City of Albuquerque
Planning Department
Development Services Division
P.O. Box 1293
Albuquerque, New Mexico 87103

OFFICIAL NOTIFICATION OF DECISION

FILE: **Project # 1003098***
03EPC-01913 EPC Site Development Plan-
Amendment to Building Permit

General Assembly Church
33115 Central Ave.
Union City, CA 94587

TITLE: SITE DEVELOPEMENT PLAN
GENERAL ASSEMBLY CHURCH OF ALBUQUERQUE, N.M.

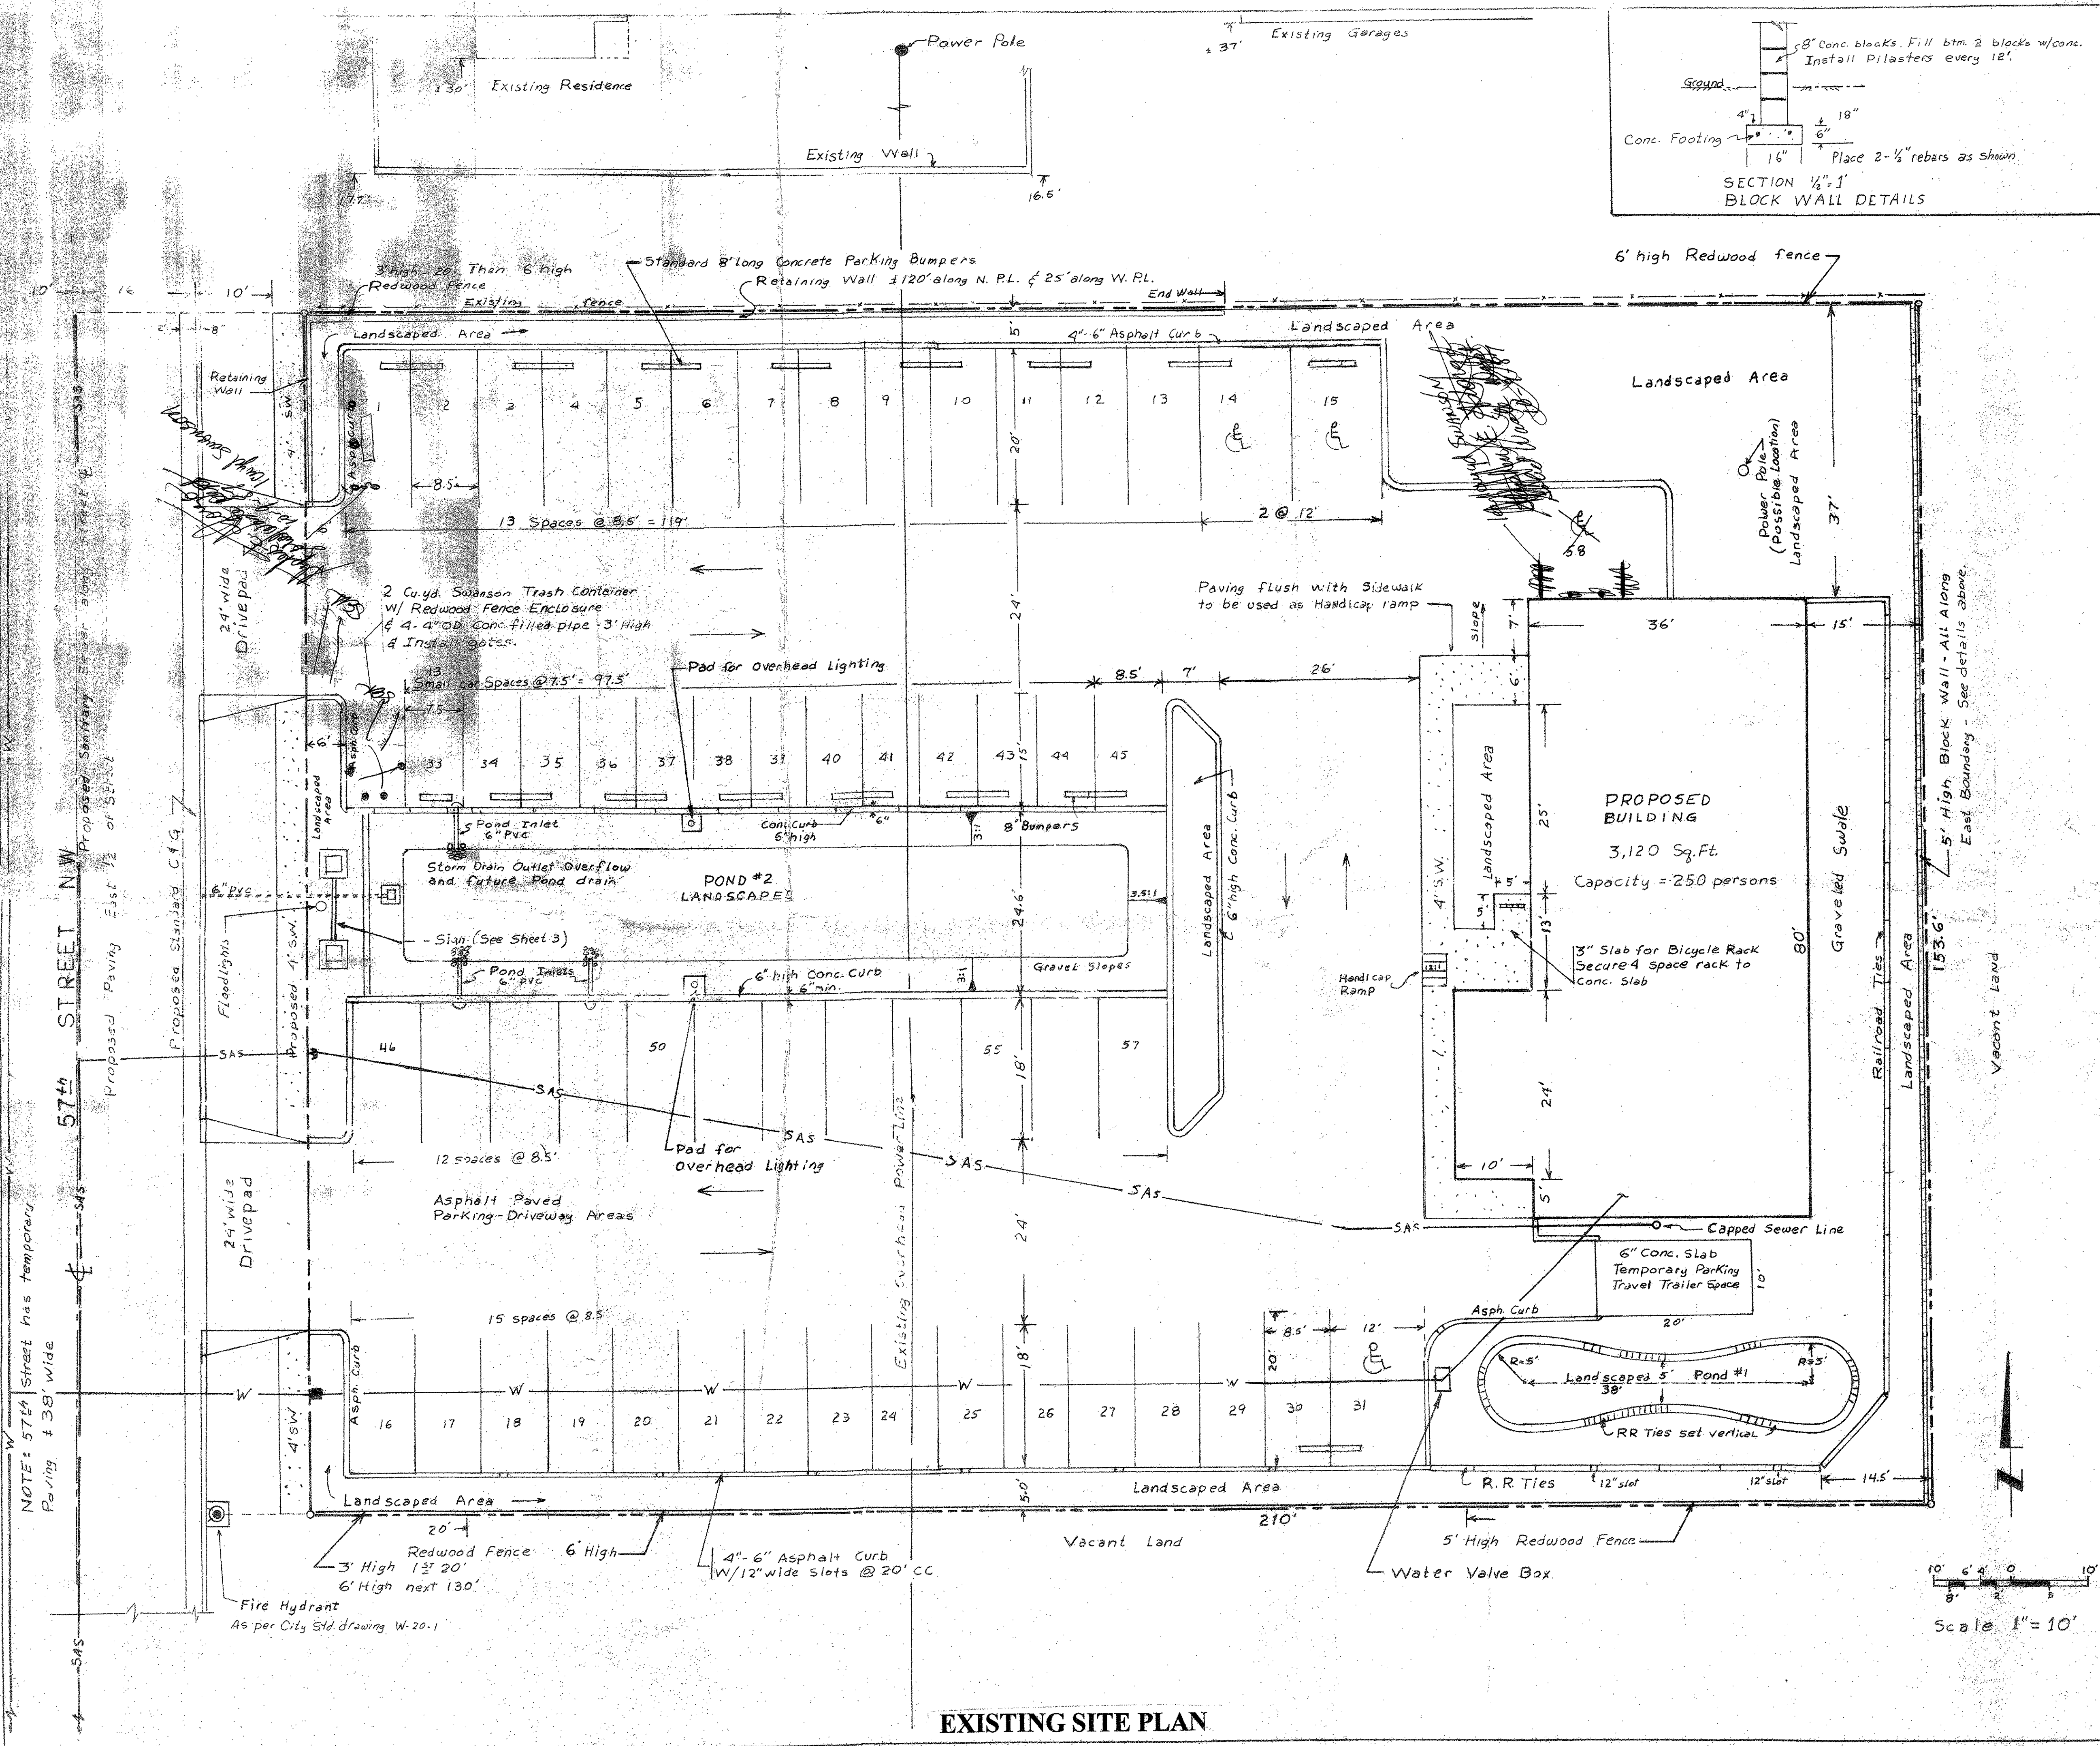
2. The site plan shall show site lighting not higher than 16-feet and a note shall be added to the site plan that no lighting that is within 100-feet of residential zoning shall be higher than 16-feet. In addition, exposed or unshielded lights are prohibited and all lamps shall be furnished with a full cutoff, shoebox type fixture.

3. The approximately 5-foot high iron fence and gates that border the west side of the property shall either be removed, or shown on the site plan and approved by the EPC.

- c. Site plan shall comply and be designed per DPM Standards.
7. The Plans shall be stamped by an Engineer or an Architect prior to issuance of building permit.

TITLE: LANDSCAPING PLAN
 JEHOVAH'S WITNESSES
 KINGDOM HALL WESTSIDE CONGREGATION

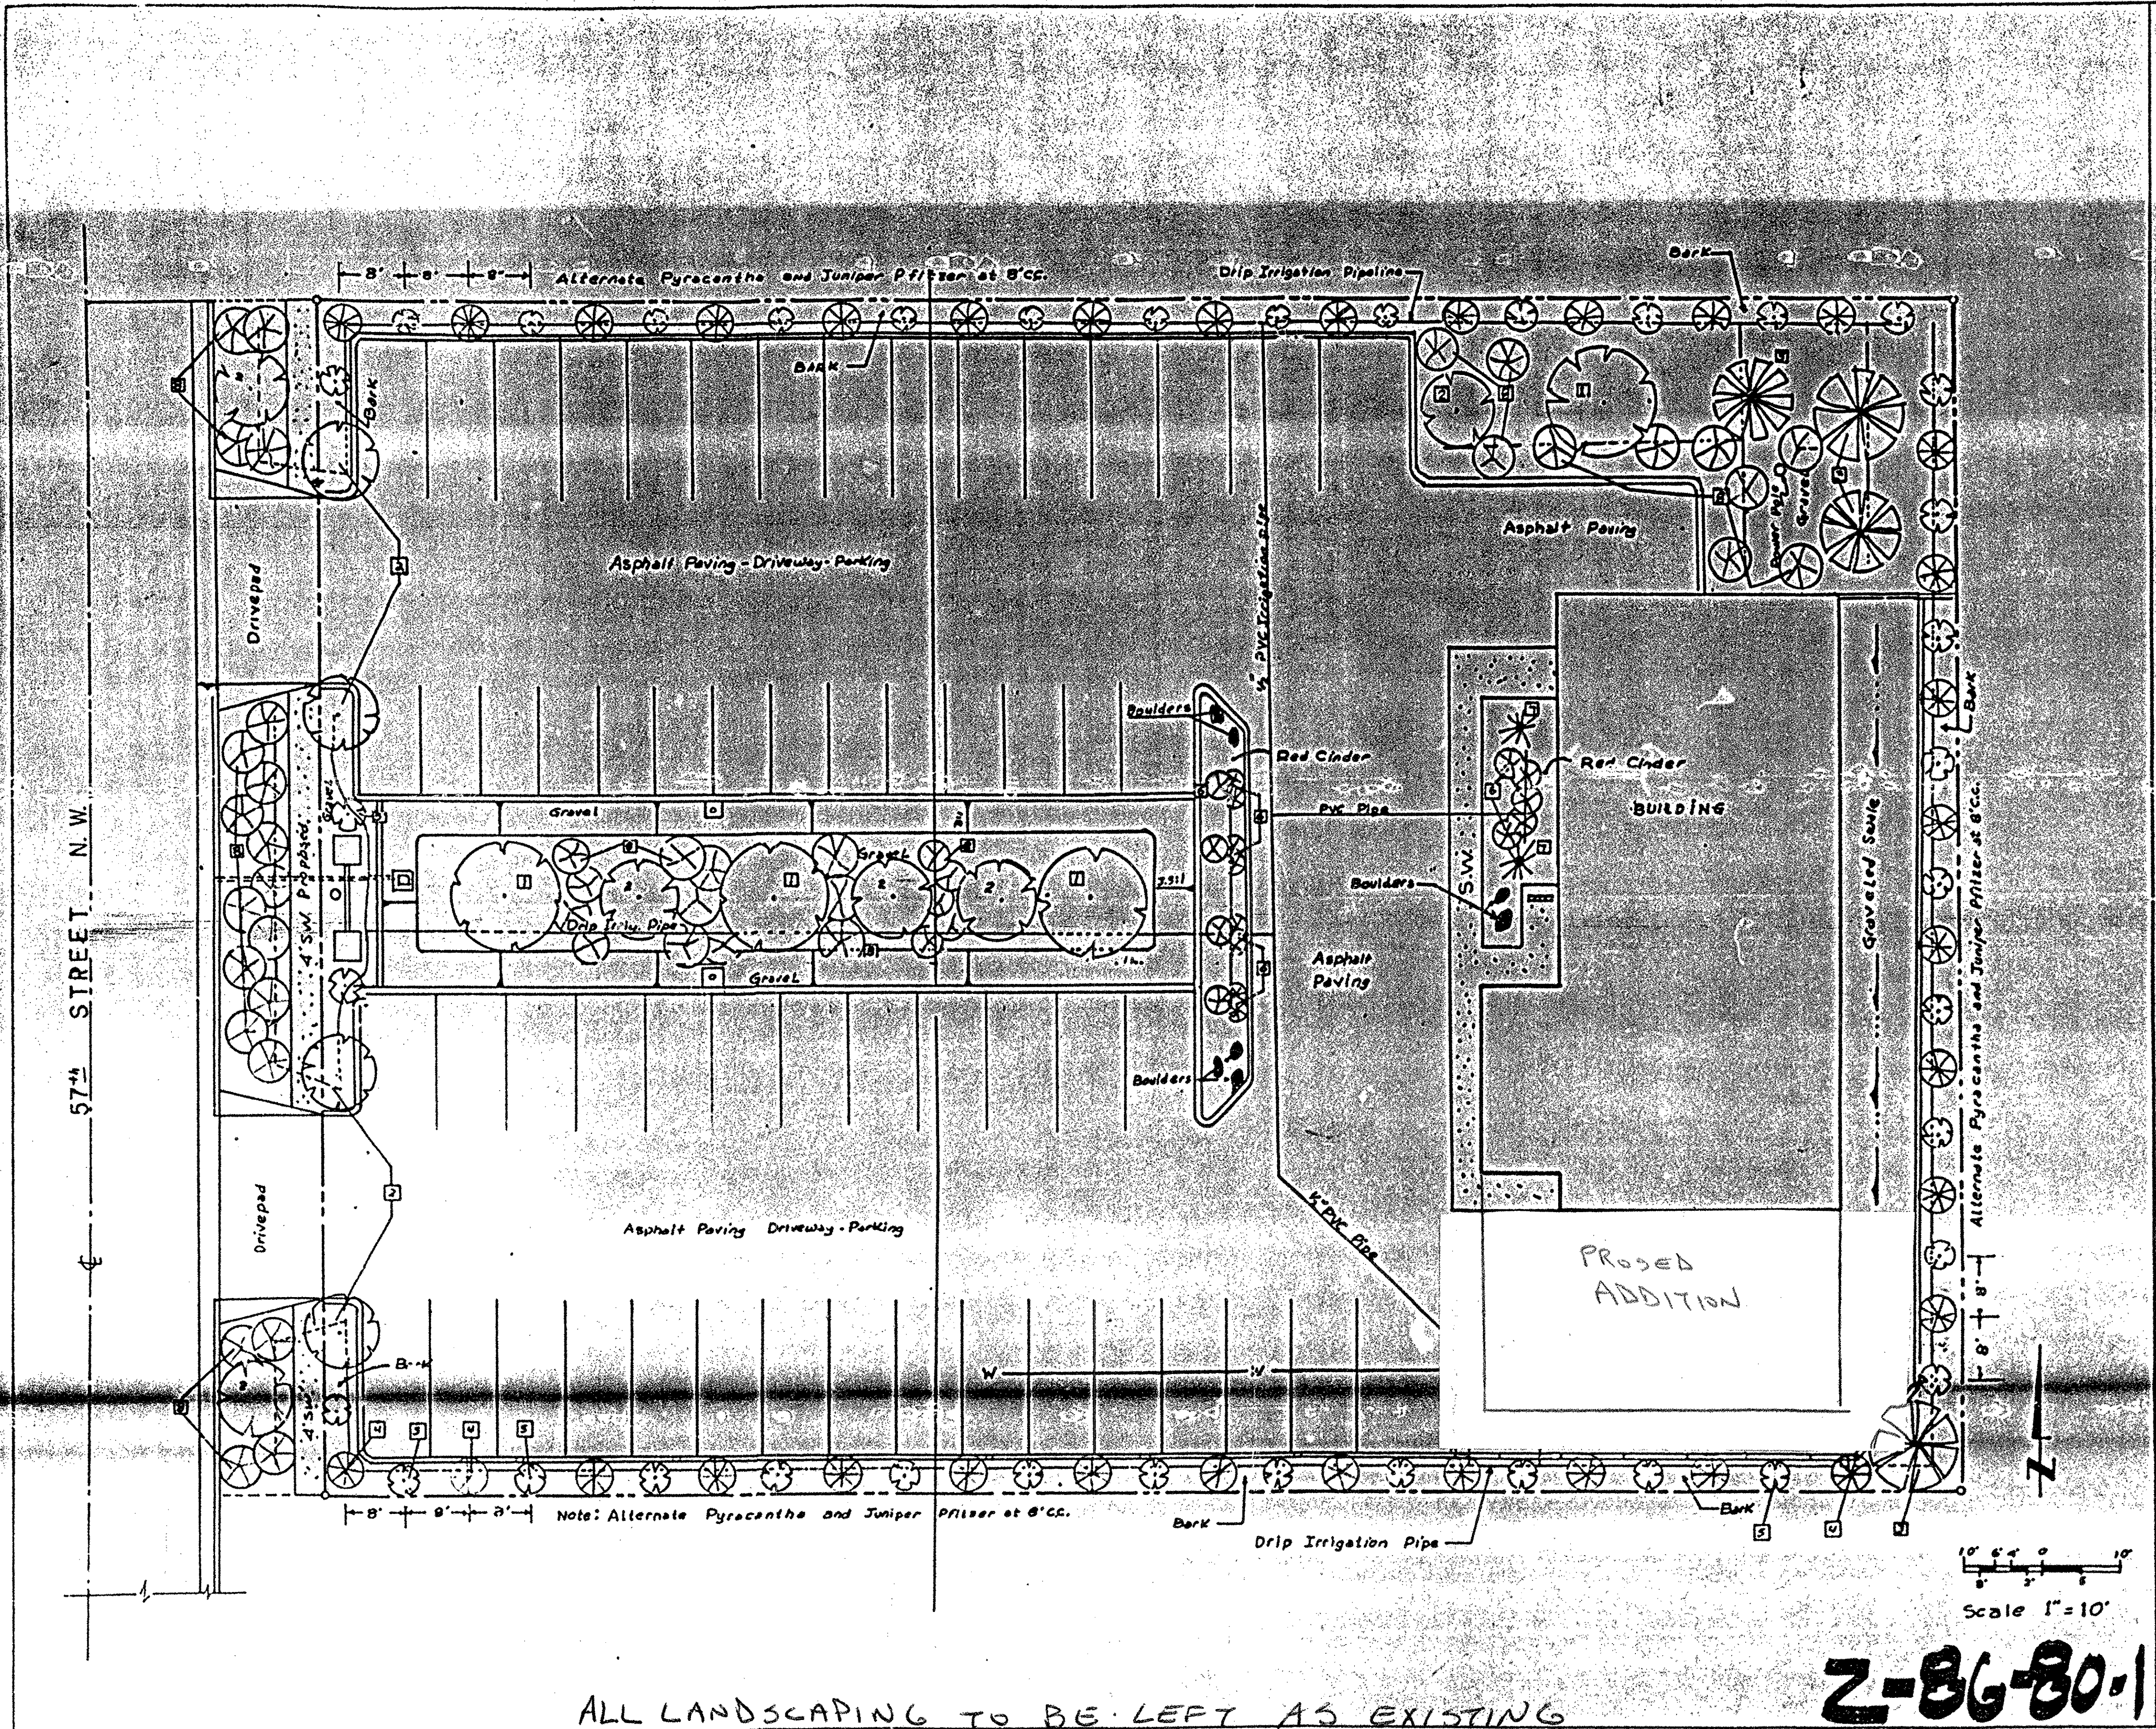
4. Landscape Plan:
 - a. All planting beds shall show the number, spacing and type of plants shown on the originally approved landscape plan dated 1-87. Shrubs such as Chamisa, Rosemary or Stipa grasses may be added to the plant palette for variety.

- b. The Juniper Pfitzer is a prohibited tree under the pollen Ordinance. Therefore, small ornamental trees such as Vitex or Desert Willow shall be used in its place.

- c. A minimum of 20 percent of the parking lot area shall be landscaped and landscaping shall consist primarily of shade trees and shrubs and shall be distributed throughout the parking lot as per the *Coors Corridor Plan*.

- d. One tree shall be planted per every 10 parking spaces and shall be distributed such that at least one tree shall be planted per every 15 linear parking spaces.

- e. Gravel, colored rock, bark and similar materials shall not be used as groundcover. Bark and gravel shall only be utilized as mulch, not as a permanent form of groundcover.

- f. Planting beds shall achieve 75% coverage of live plantings at full maturity.
5. Signage, including the base of the sign, shall not exceed 9 feet in height, as per the *Coors Corridor Plan*.
